Re: SSD 6339 St Catherine's School Campus Master Plan

Eastern Suburbs Local Area Command on behalf of the New South Wales Police Force welcomes the opportunity to provide comment on the above development application submitted and currently under consideration.

This submission is predominantly providing comment on areas of concern held regarding the foreseeable transport and road network impacts the proposed development application will have. Eastern Suburbs Local Area Command does not object to the development application per se however, would like to make comment on these individual areas of concern in anticipation of a solution being developed as part of the development consent.

TRAFFIC MANAGEMENT AND PARKING

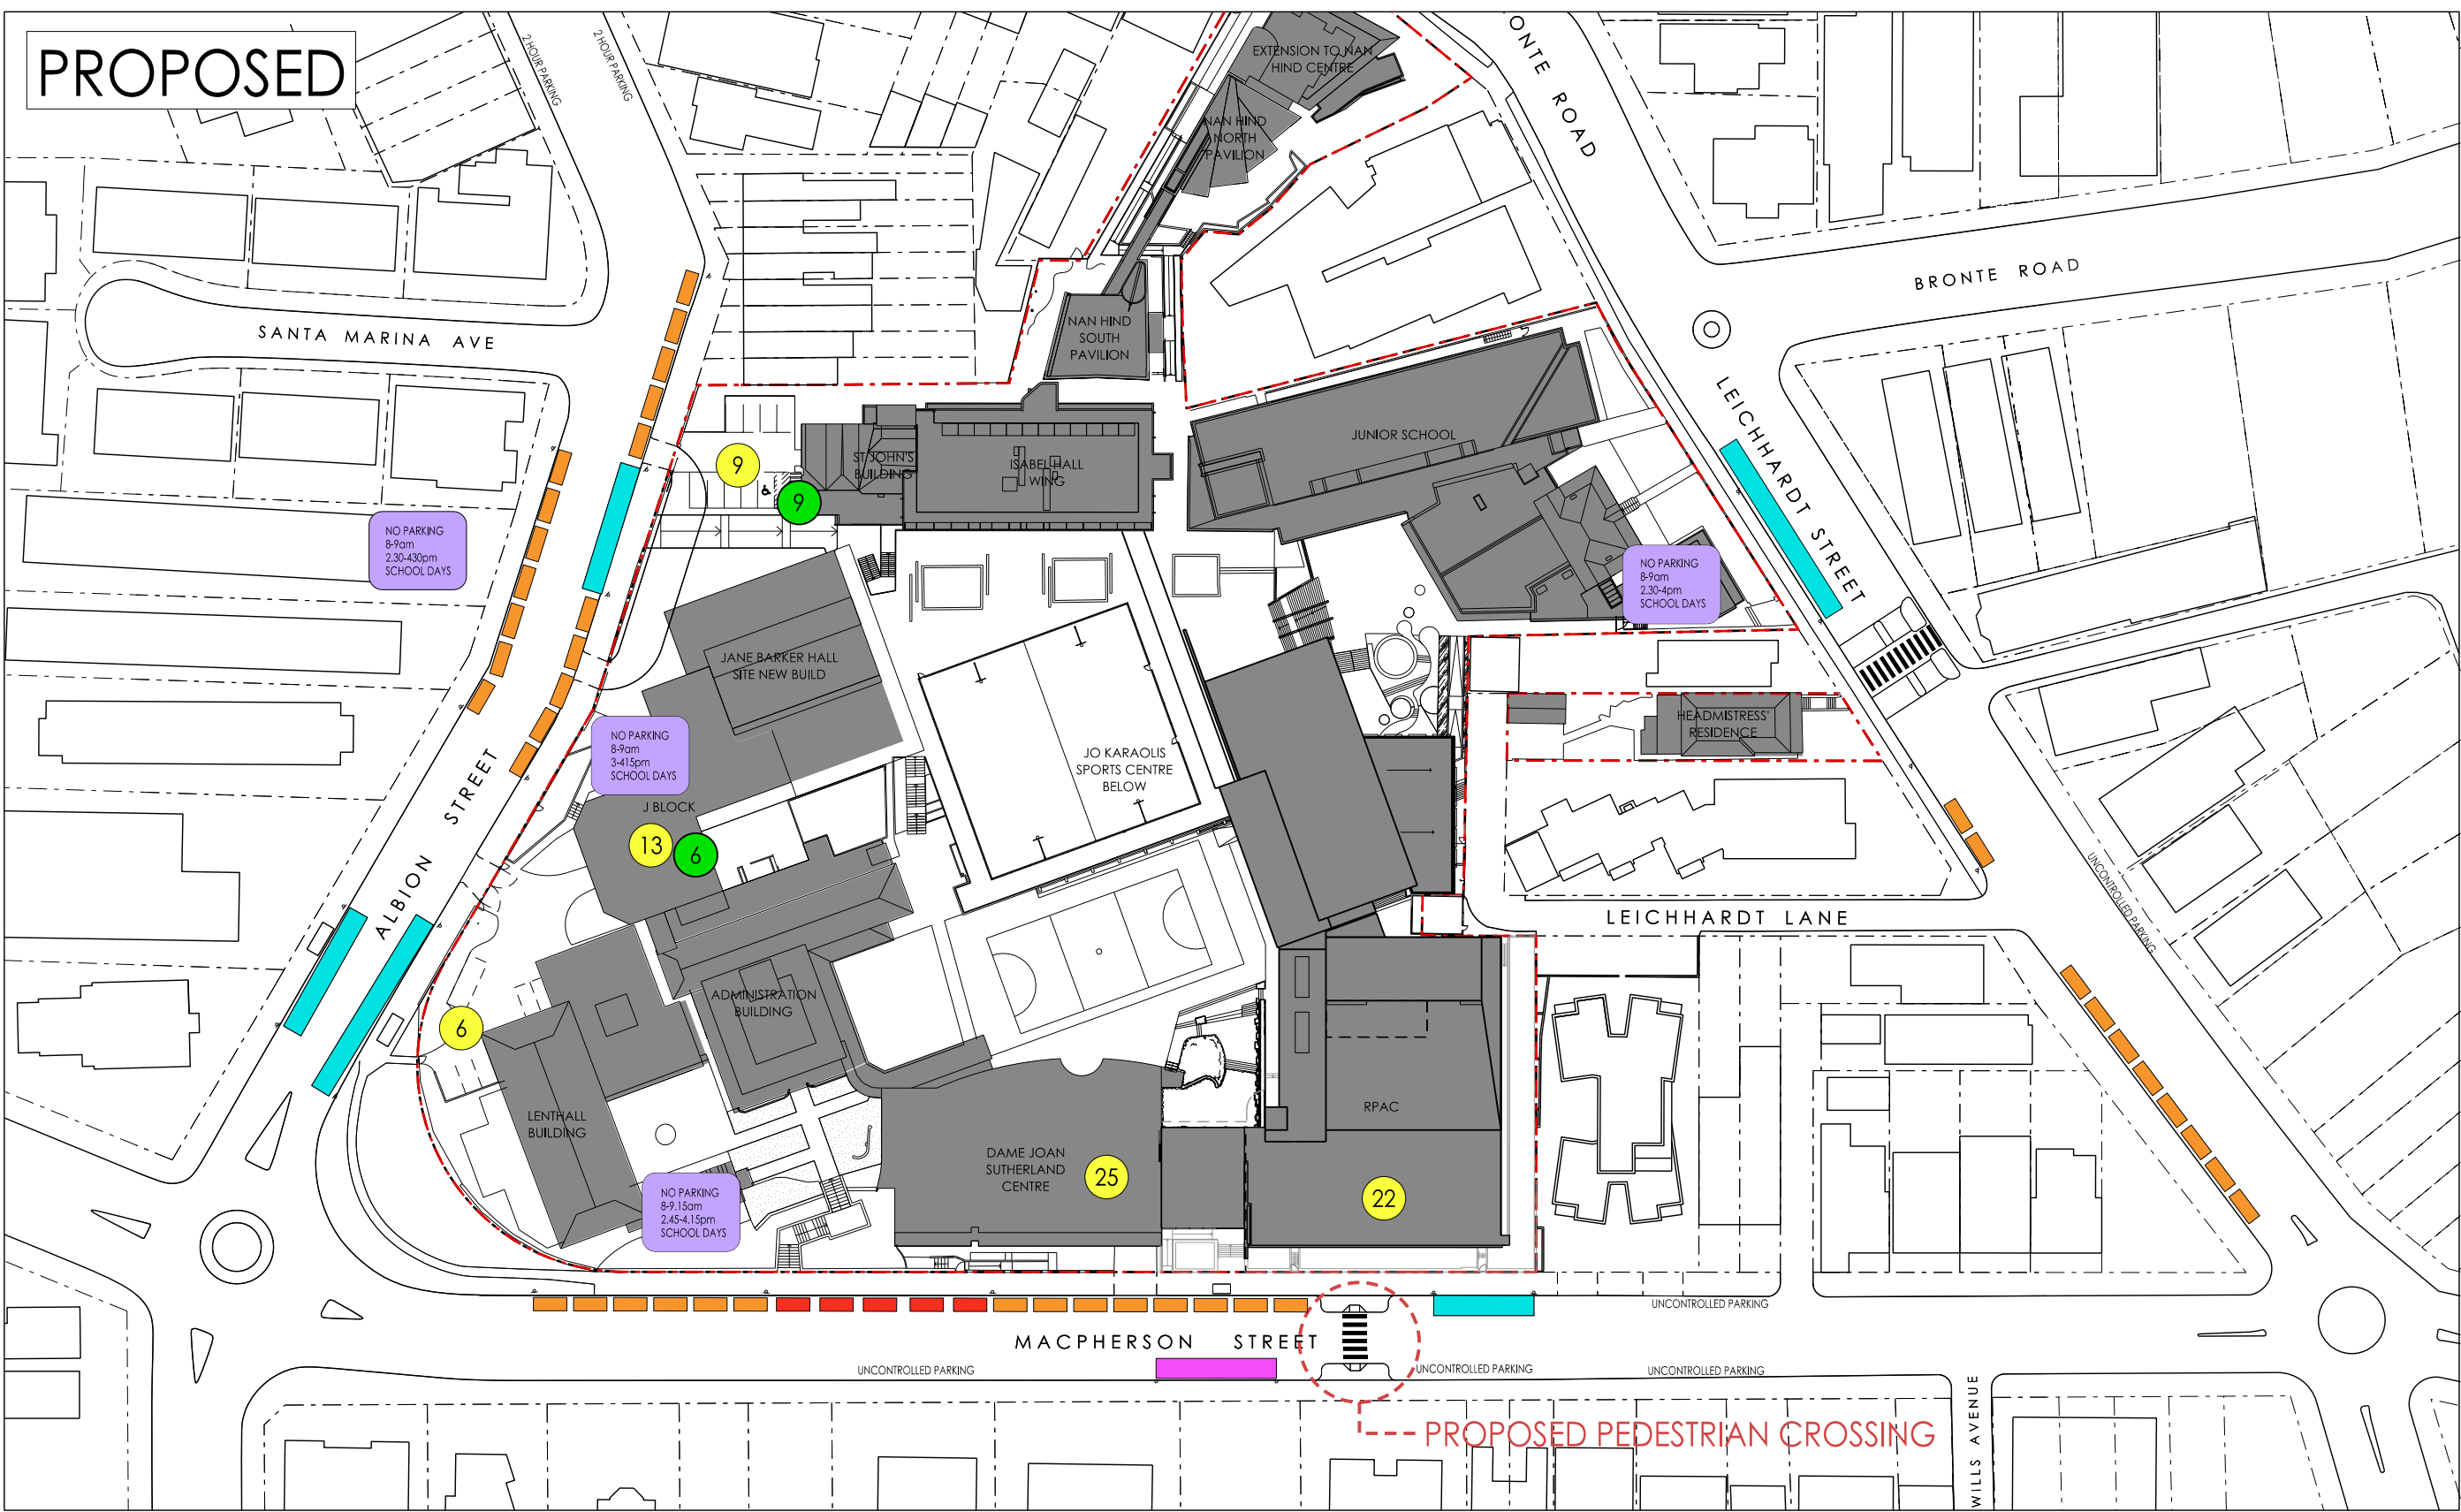
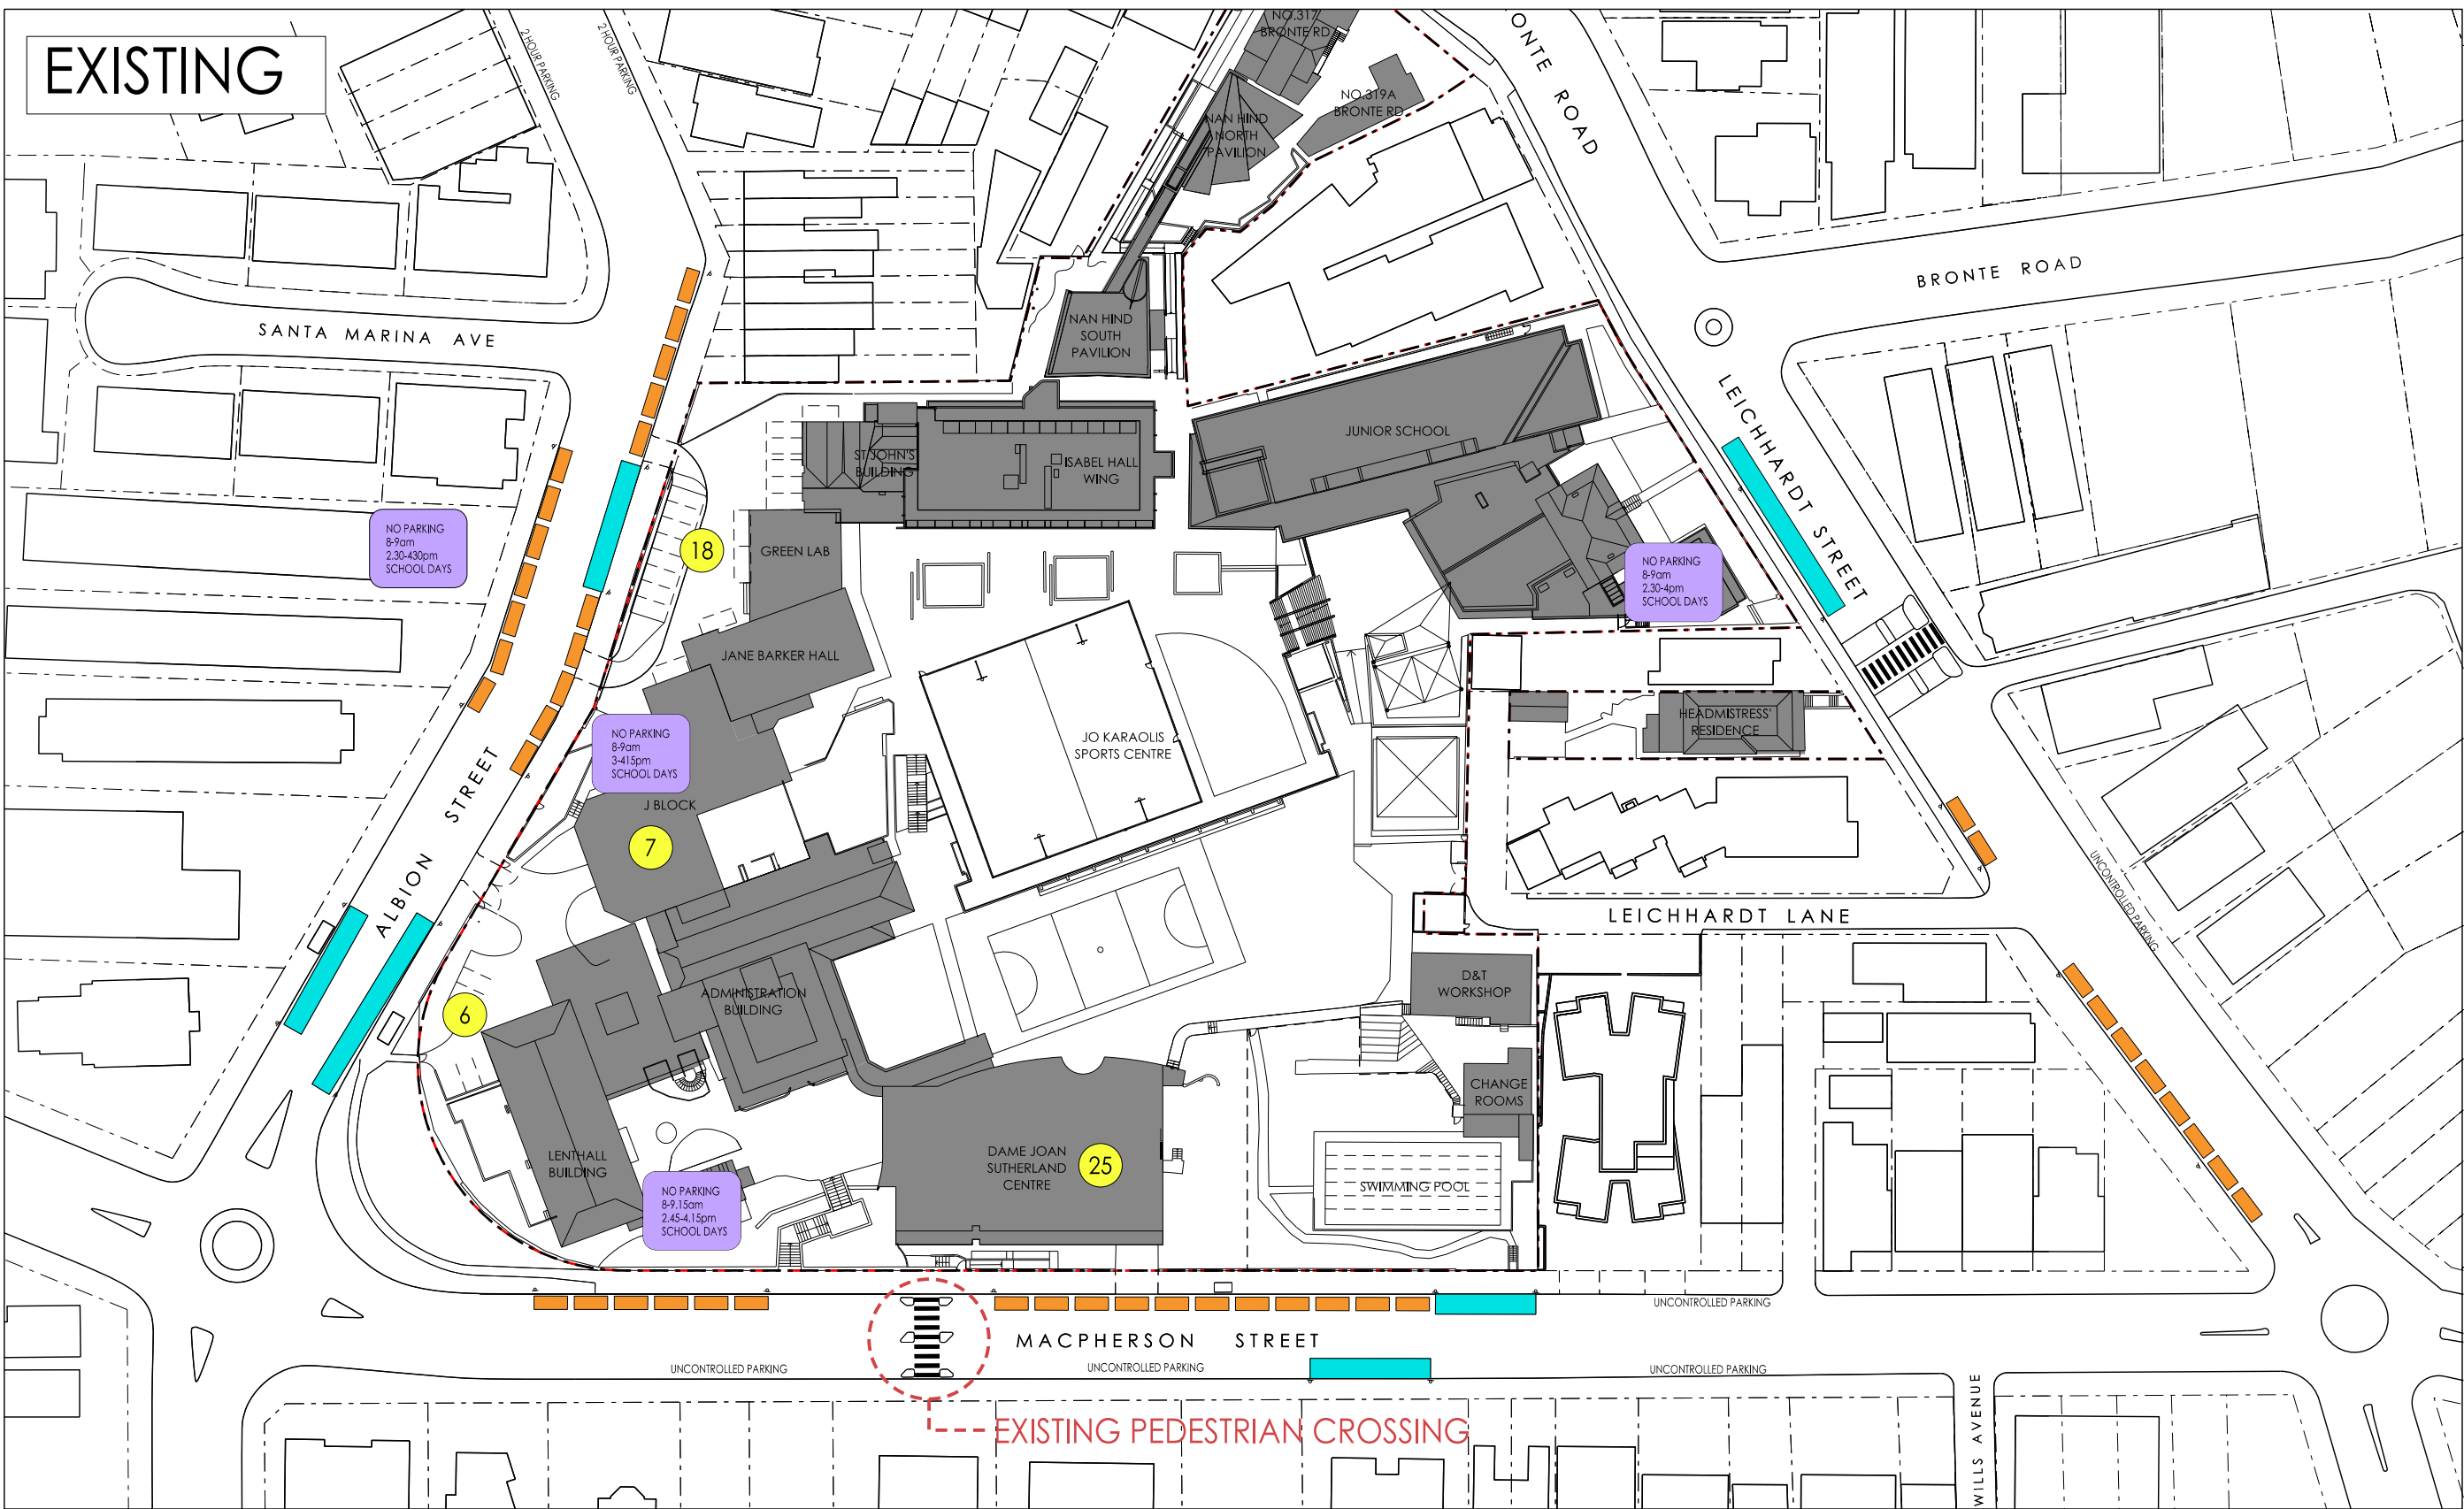
Further consideration needs to be given to significantly increasing the use of bicycles as a mode of transport. The provision of fifteen bicycle spaces (circa 1% provision compared to the School's future capacity) is insufficient for the school to effectively encourage the use of bicycles nor does it provide an incentive to students and/or staff to change their mode of transport.

Eastern Suburbs Local Area Command submits that off street parking will need to be increased to an appropriate figure not less than 200 to accommodate the increase in functions and the capacity of venues within the School. This will ease the pressure on the road network and the available parking therefore reducing the impact on the non-school community.

**Figure 21: Proposed site access points and circulation**

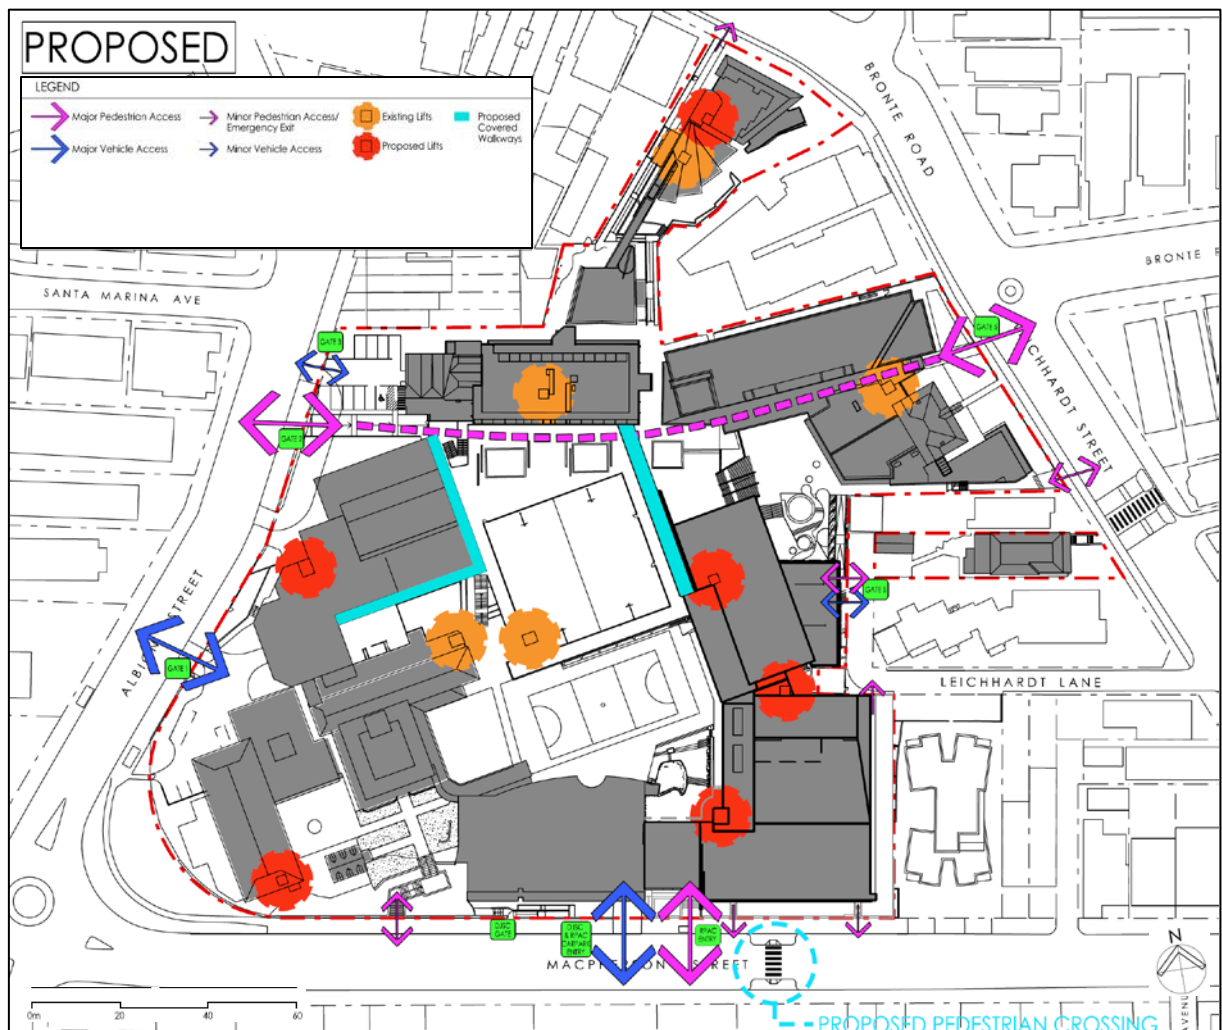
Due to the previously mentioned road network congestion and the increase in vehicle movements to and from the RPAC, it is submitted that the car park entrance operate on a 'left turn in, left turn out' basis. This will prevent west bound vehicles being obstructed waiting for another to conduct a right turn into the car park, and would also prevent vehicles attempting to turn right out of the car park effectively forcing their way out into traffic. This will increase the free flow of traffic on Macpherson Street, improve road safety by requiring vehicles to utilise round-a-bouts installed at either end of the block and will go towards preventing conflict with the relevant vehicle movements.

To enforce this, Eastern Suburbs Local Area Command submits that a raised concrete median strip be installed adjacent to the car park entrance and the relevant signs be installed.
